# Comhairle Contae Chill Mhantáin Wicklow County Council

**RE: PROPOSED PLANNING APPLICATION FOR DEVELOPMENT OF 426 RESIDENTIAL UNITS AT  
FARRANKELLY, GREYSTONES, CO. WICKLOW.**

Ground Floor Plan

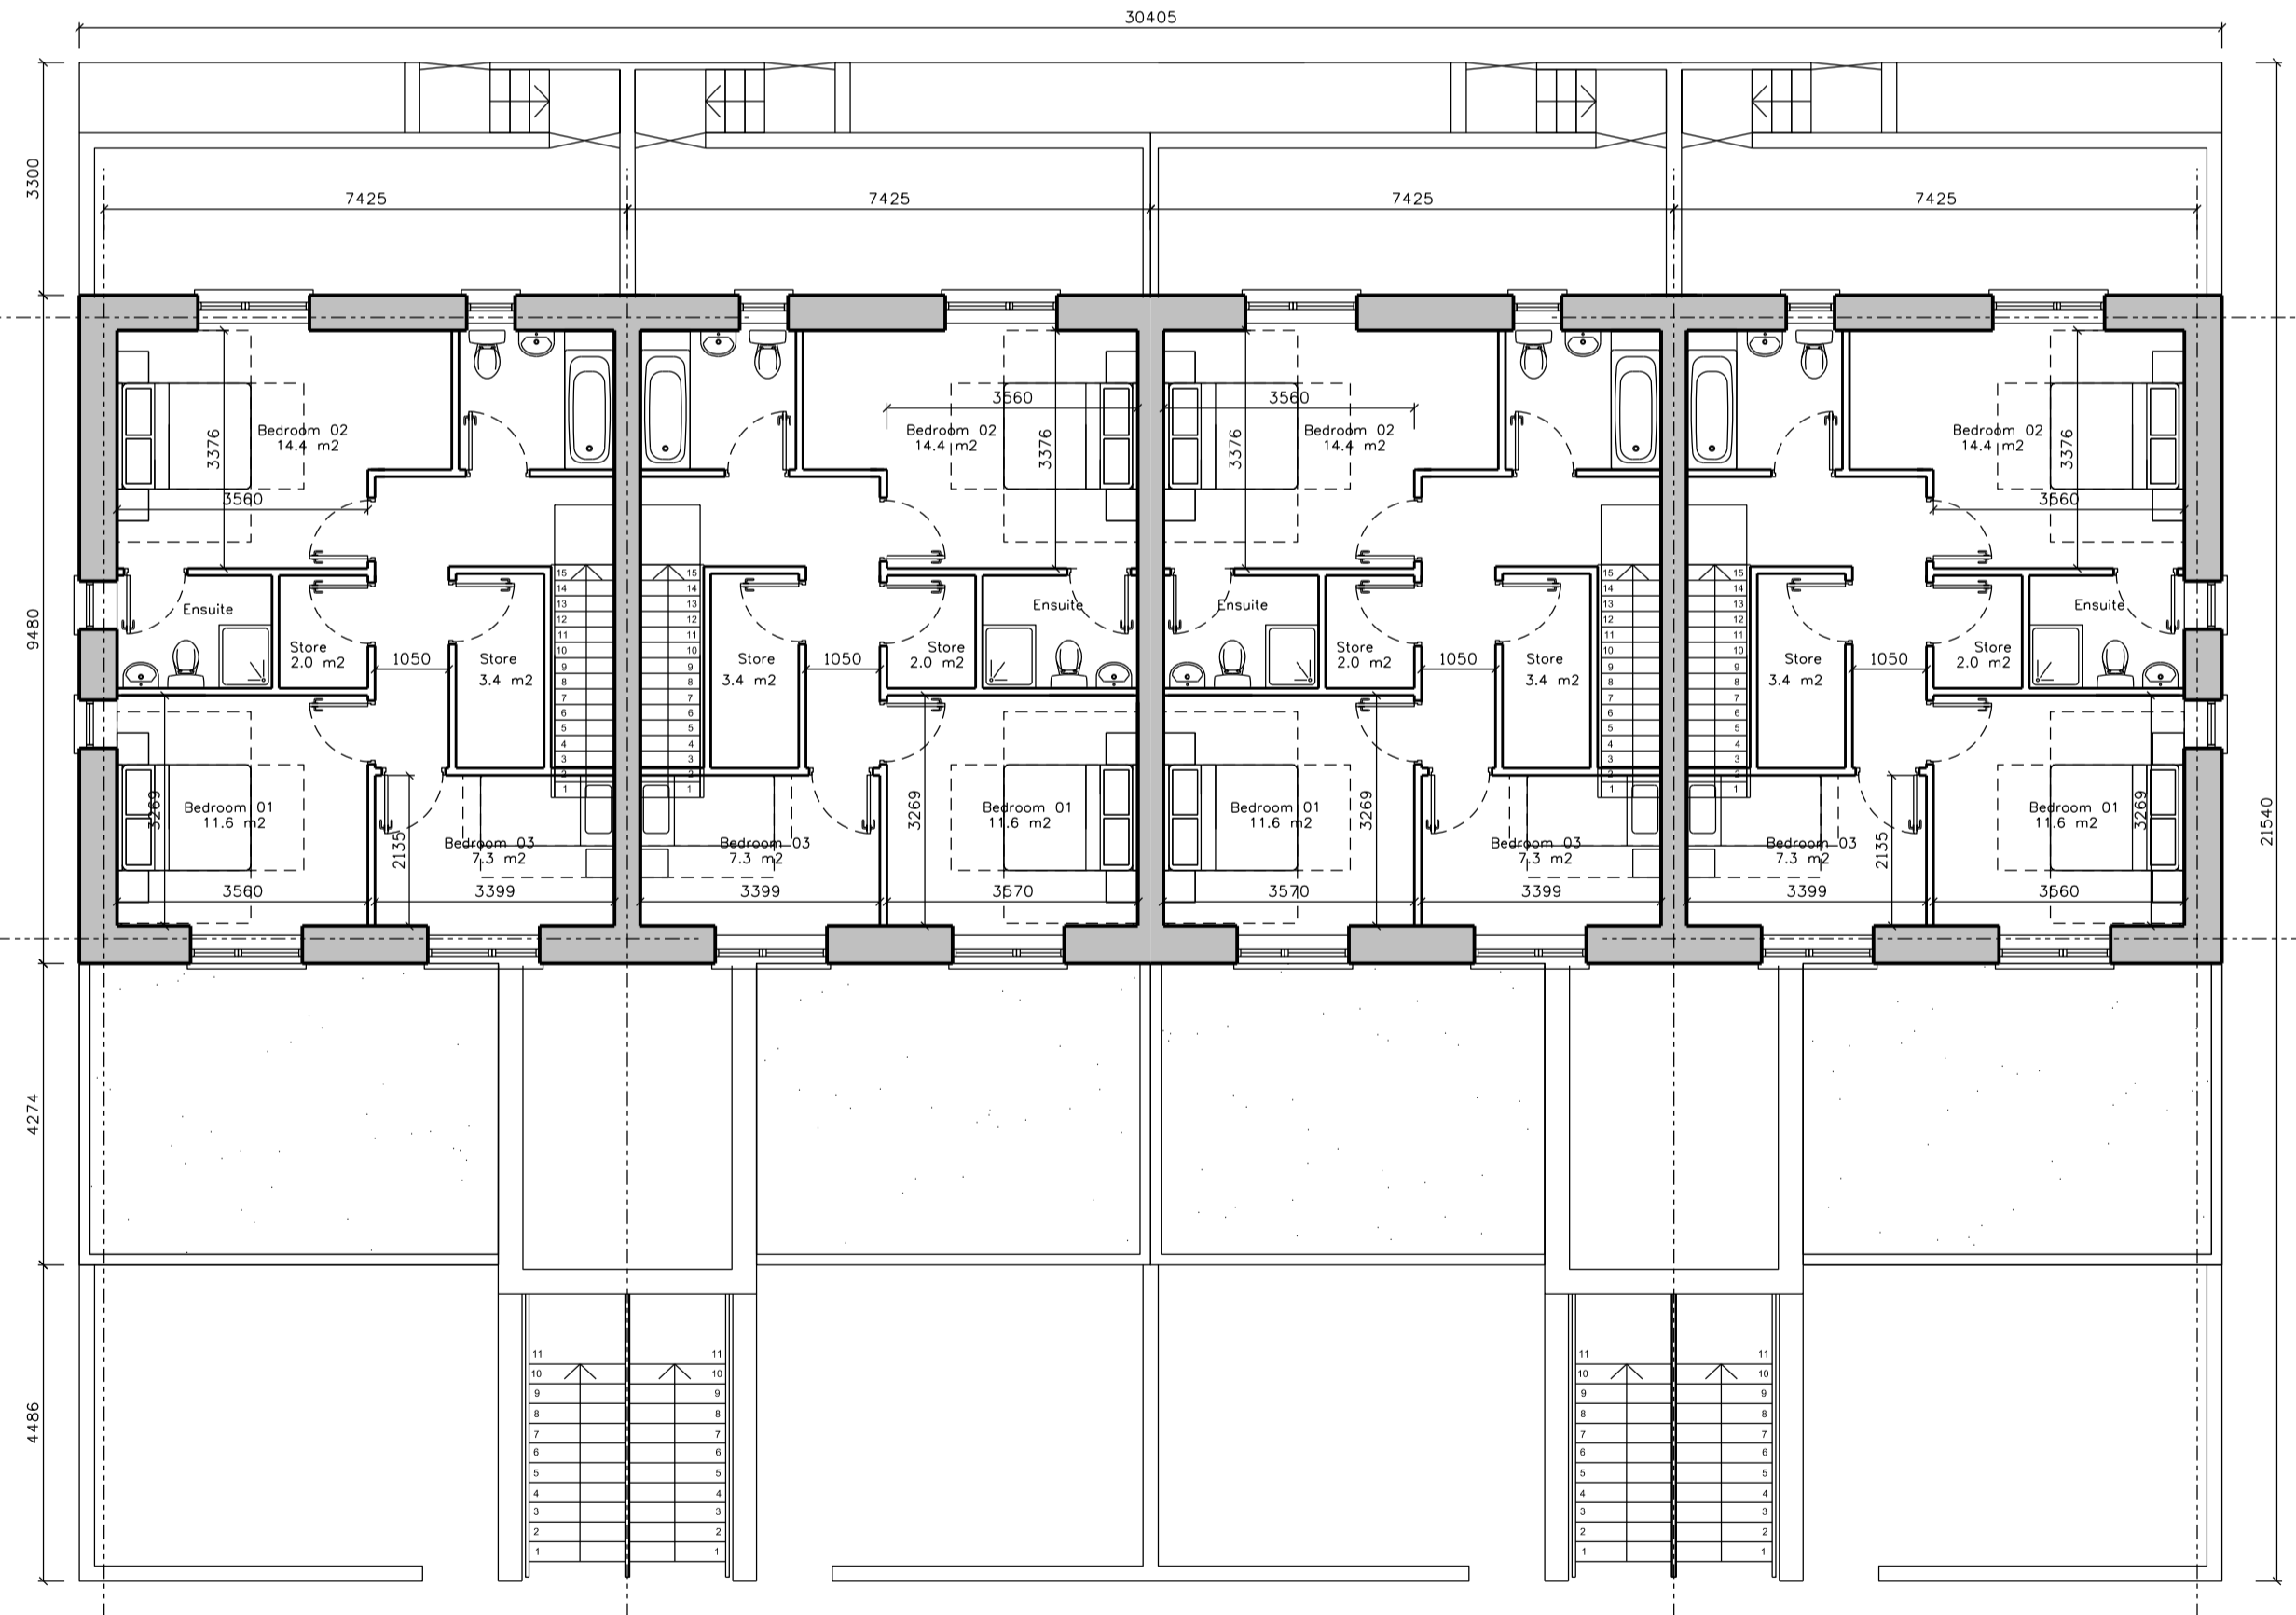
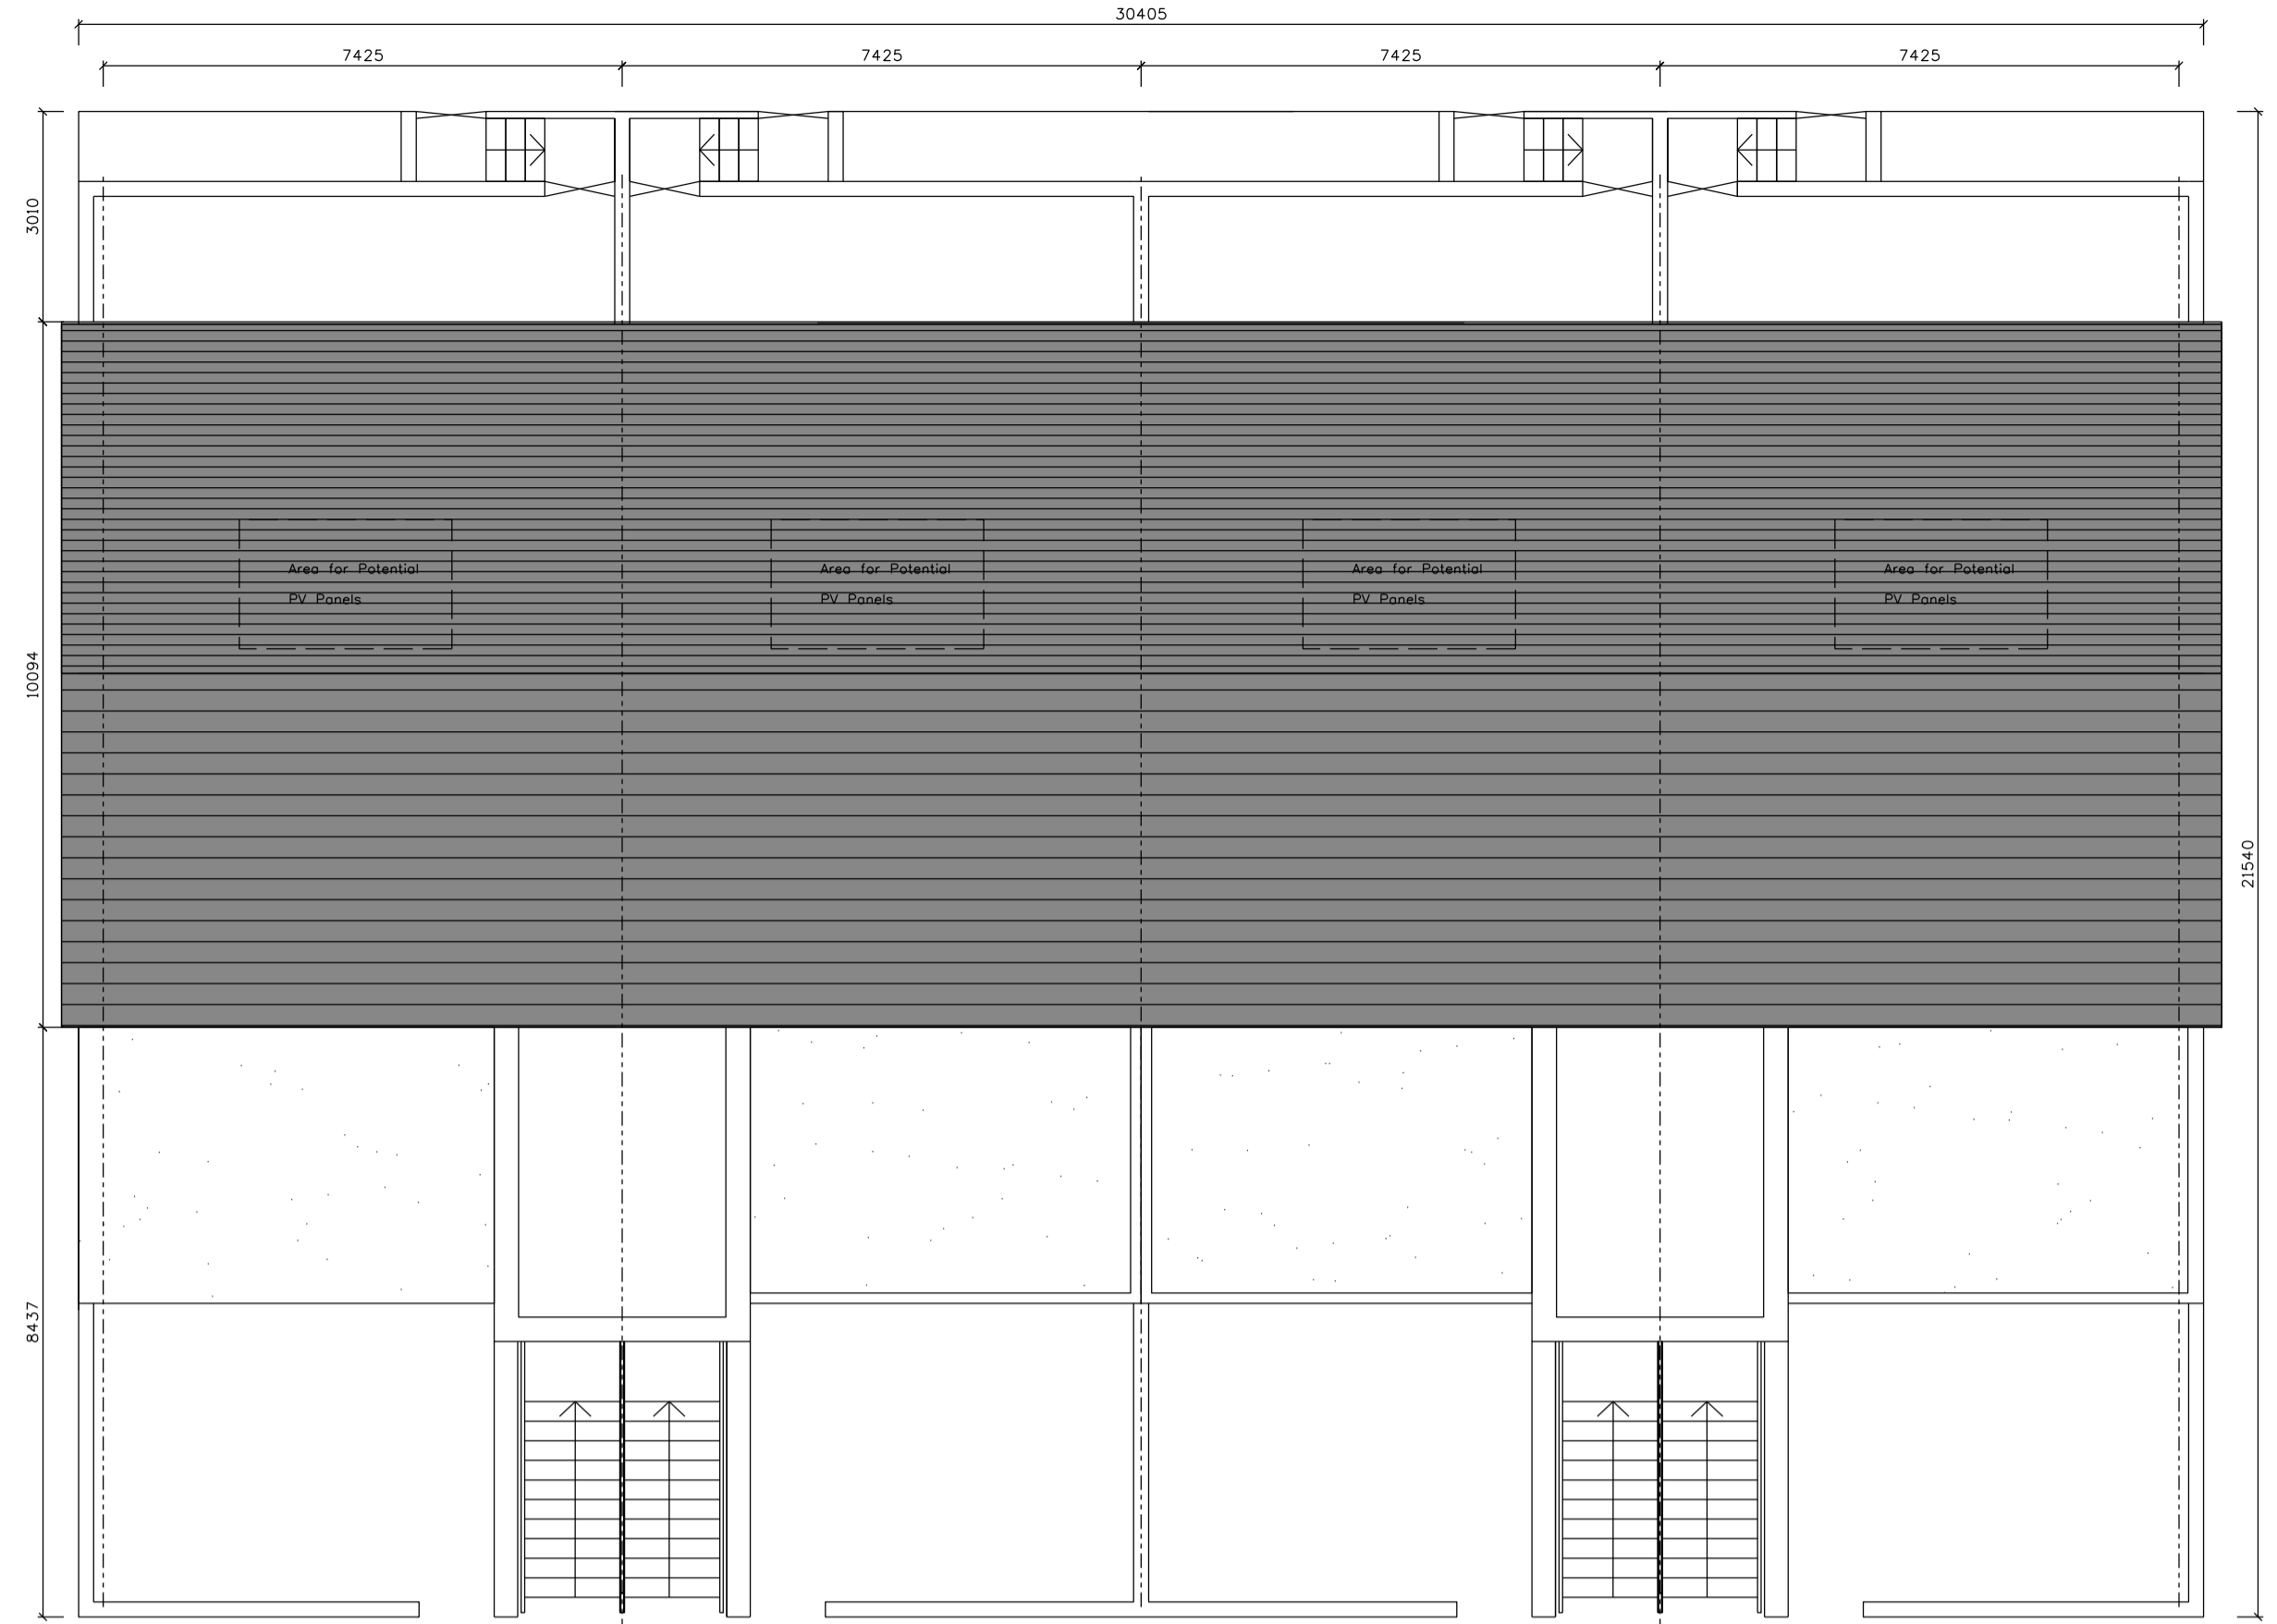
- 3 no. 3 x bed 5 person town houses type B2. The units are oversized at 114.5sqm the current target is 101sqm. The en-suites are not required.
- 4 no. 2 x bed duplex ground floor apartments. The units are oversized at 89.5sqm the current target area is 80sqm.
- 4 no. 3 x bed duplex 2 storey apartments. The units are oversized at 121sqm and the target area is 101sqm. En-suites should be removed if possible.
- 19 no. 2 bed apartments. The units appear to be oversized at 85/86sqm. The target area for a 4 person 2 bed apartment is 80sqm. En-suites should be removed if possible.
- 12 no. 1 bed apartments. The 1 x bed apartments appear to be marginally oversized at 51sqm and the target area is 50sqm but may be acceptable.
- All of the apartments have shared entrances – the Council's preference is for own door units.
